Recommendation Report for Planning Permission for Works or Extension to a Dwelling

REF NO: FP/251/18/HH

LOCATION: 39 Limmer Lane
Felpham
PO22 7HD

PROPOSAL: Detached carport and garage

Title
Block and Location Plans

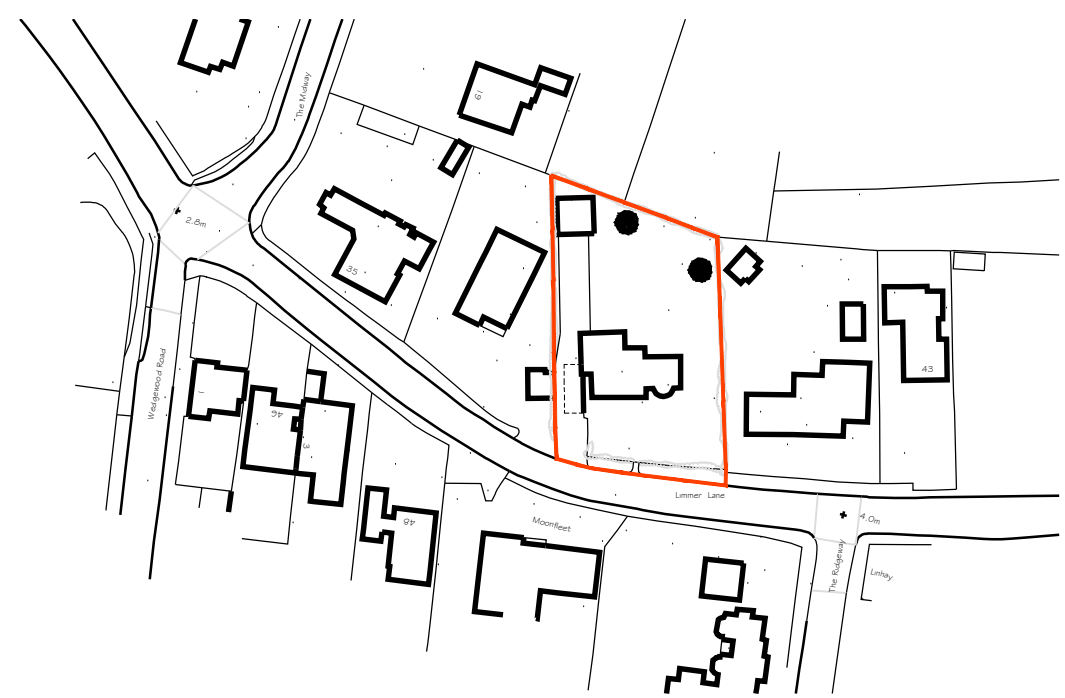
The development will have a width and length of 6m with 1m retained to the north and western boundary. With the proposal located to the rear side of the garden it retains sufficient garden space with 16m to the rear elevation of the host dwelling and a maximum of 18m to the eastern elevation. Due to the siting of the garage and the boundary treatment it is not considered any overshadowing or overbearing upon the neighbouring property to the west would be significant in which a refusal is justified.

Title
Detached carport and garage

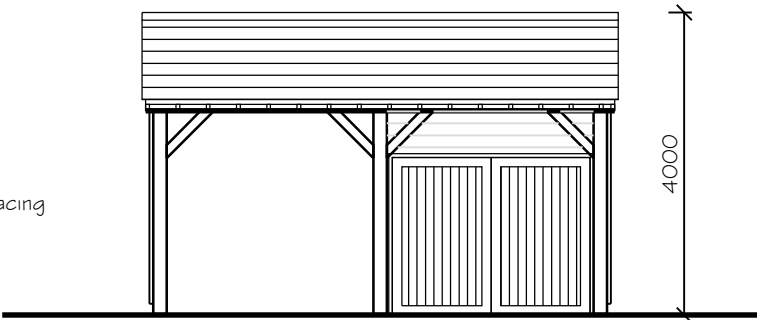
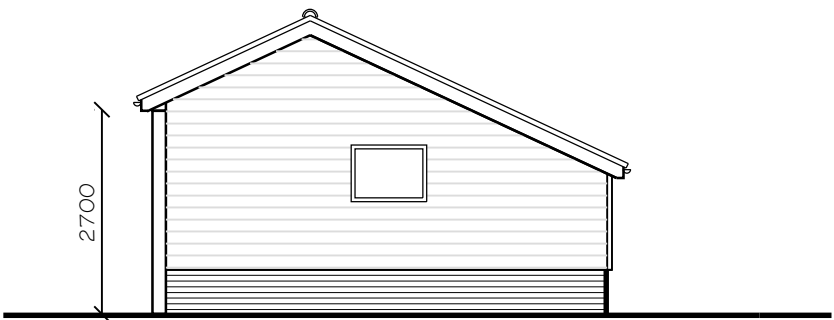
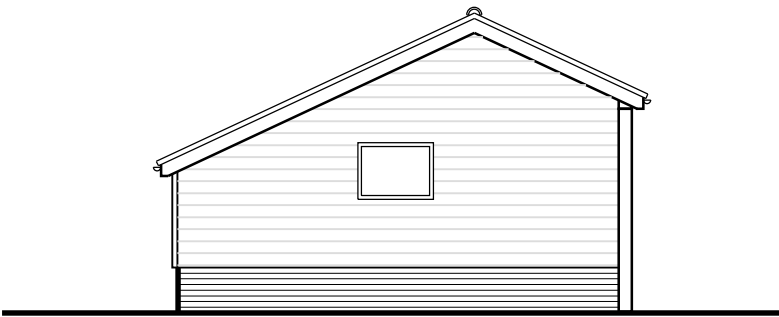
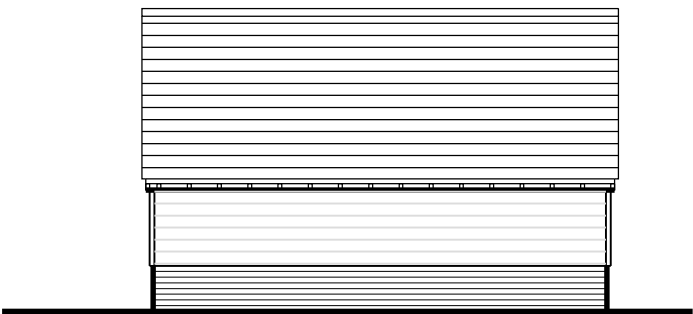
The carport and garage whilst relatively tall at 4m due to its siting at the rear is not considered to appear unduly dominant. There are various detached garages within the vicinity and therefore also is not considered out of character. The materials proposed are considered acceptable due to the siting to the rear of the property.

The proposed garage and car port will have a maximum height of 4m with a catslide roof to the rear.

The eaves will be 2.7m to the front and reduce to 2m to the rear boundary. which is considered to reduce any impact of overbearing or overshadowing upon the property to the north.
